Our ref: HA/2020/121968/01-L01
Your ref: A/177/19/PL
Date: 06 February 2020

NEW BUILDING FOR STORAGE OR DISTRIBUTION, LIGHT INDUSTRIAL & OFFICE (CLASS B1/B8) & ASSOCIATED PARKING. THIS APPLICATION IS A DEPARTURE FROM THE DEVELOPMENT PLAN & MAY AFFECT A PUBLIC RIGHT OF WAY.

THE VINERY ARUNDEL ROAD POLING BN18 9PY

drawing No: 19011-A-PL-007 revision: A

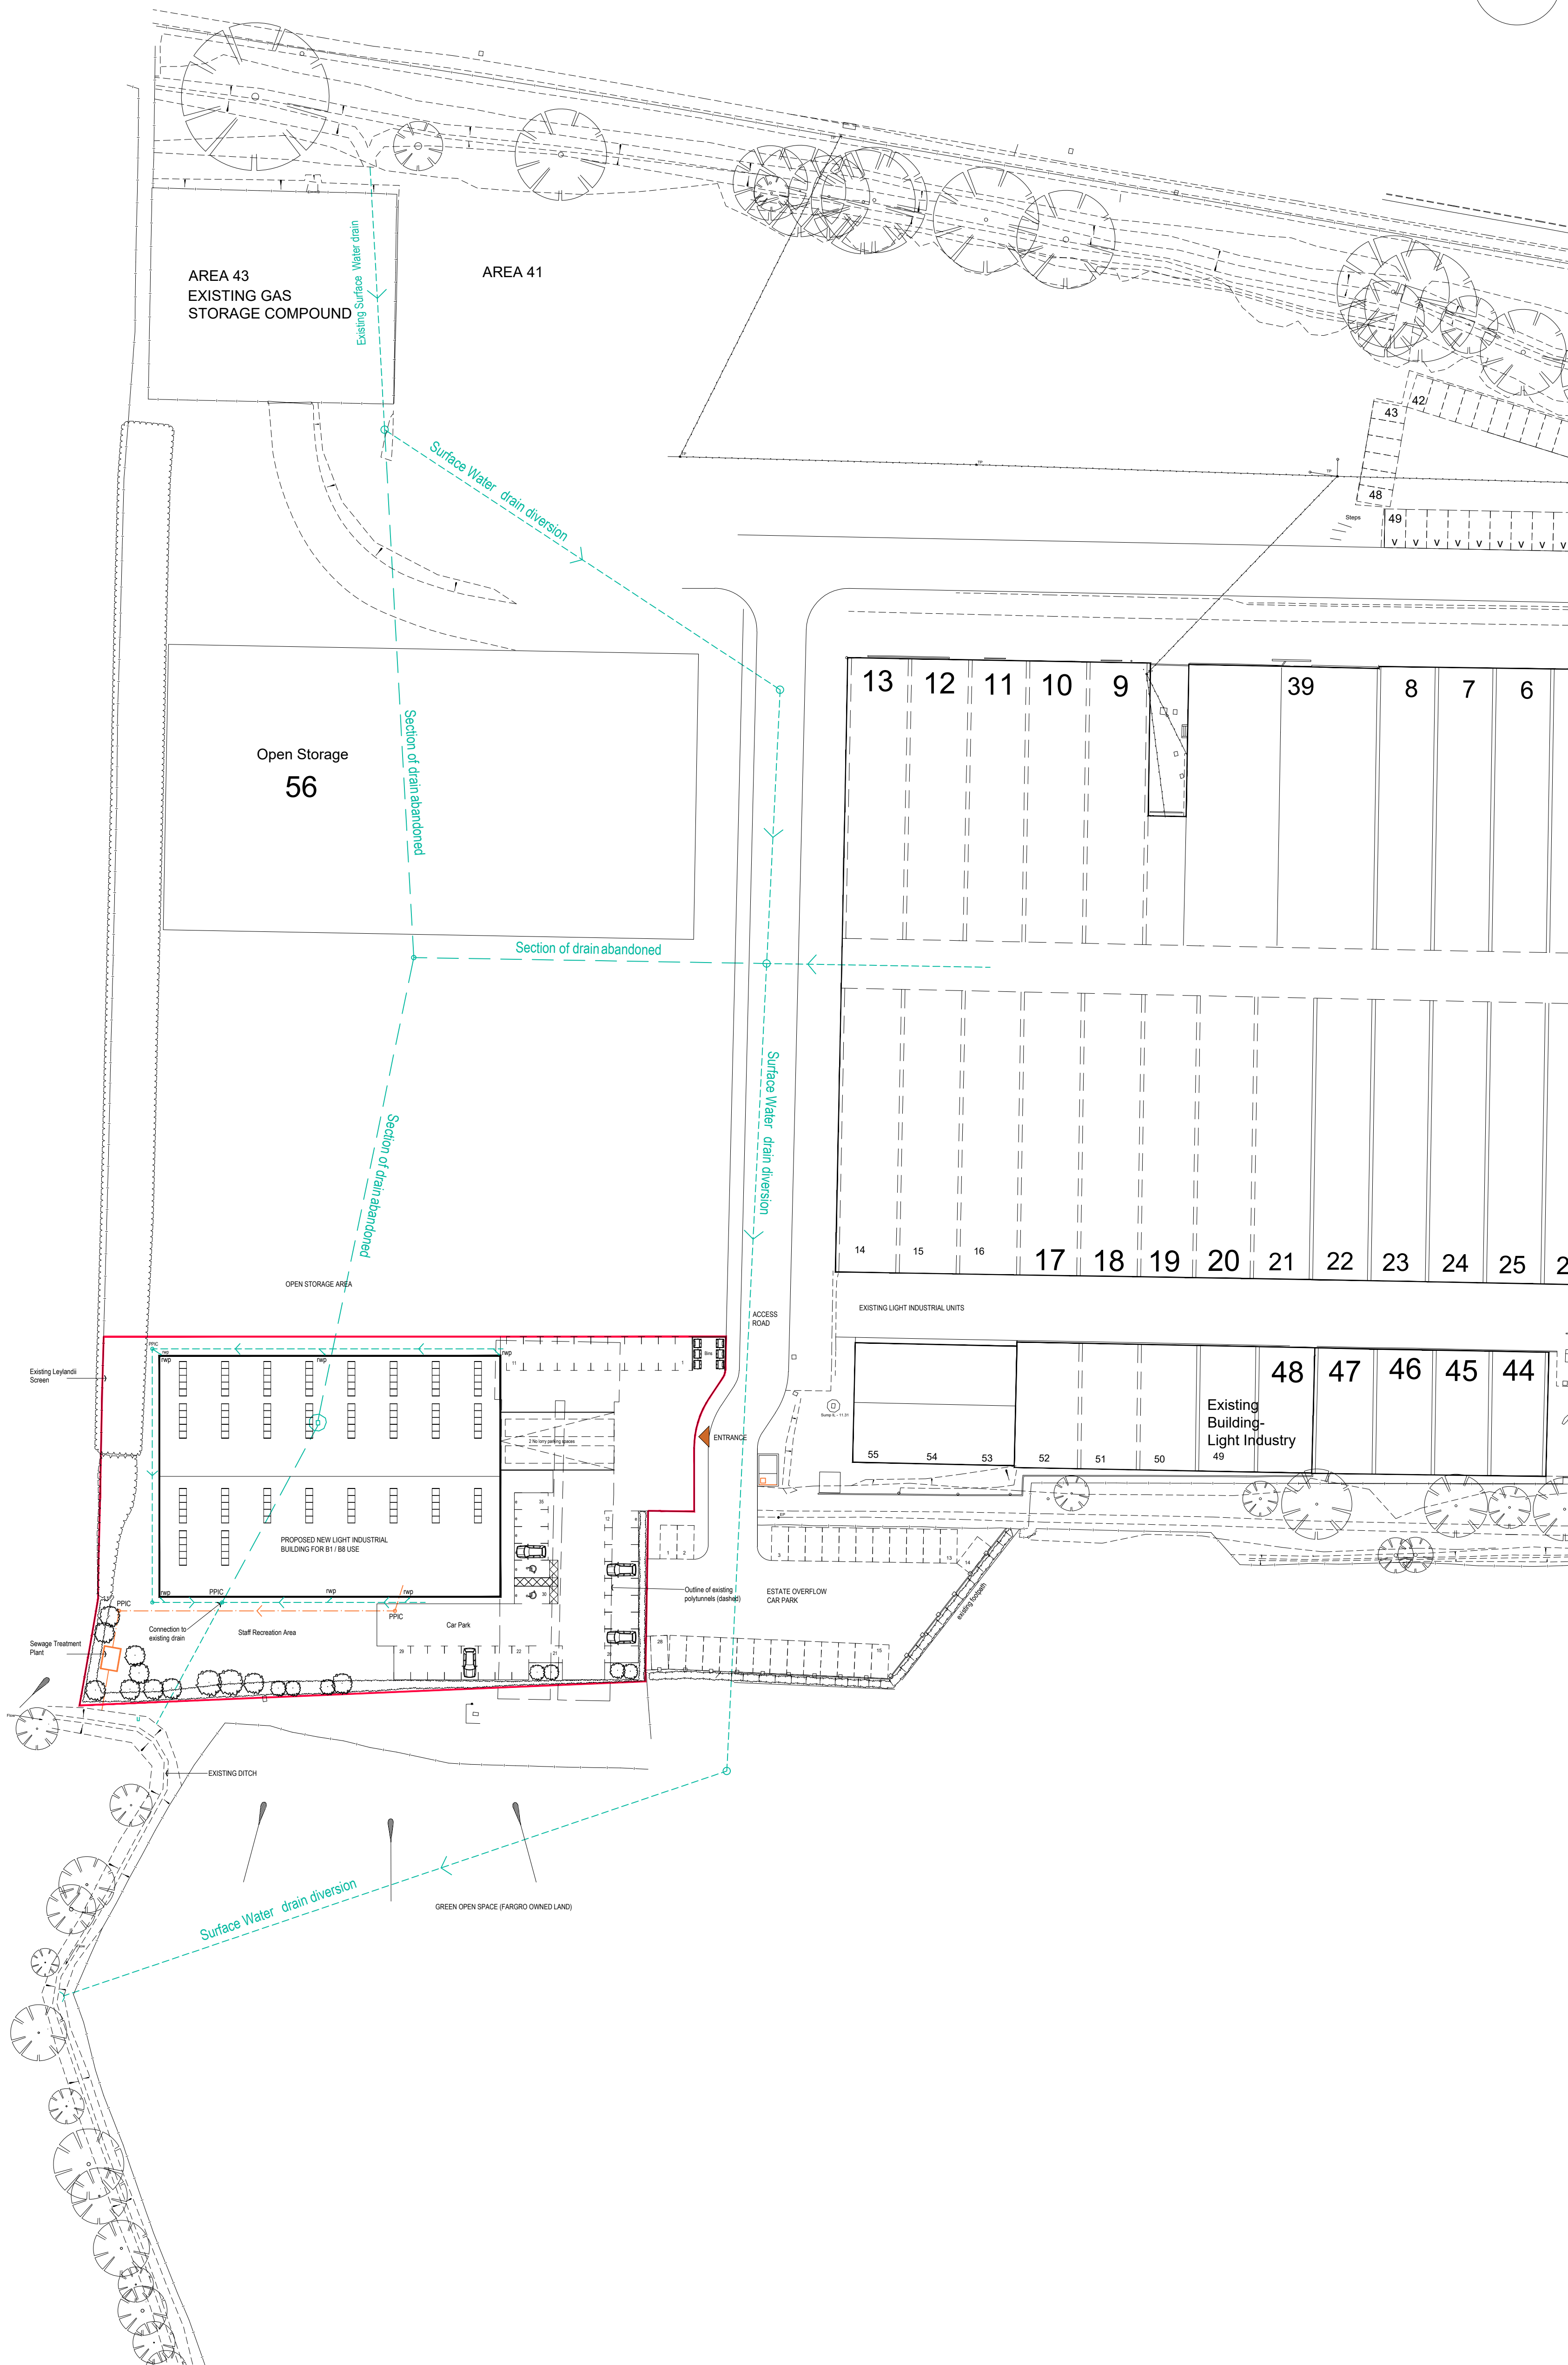
No drainage systems for the infiltration of surface water to the ground are permitted other than with the written consent of the local planning authority. Any proposals for such systems must be supported by an assessment of the risks to controlled waters. The development shall be carried out in accordance with the approved details.

As the proposed use of the site is storage/light industrial and the foul and surface water drainage, will be discharged to a surface water feature to the west of the site. Due to the potential variability of the material being stored on the site, we feel it is necessary for the applicant to demonstrate an adequate pollution prevention system for surface run off.
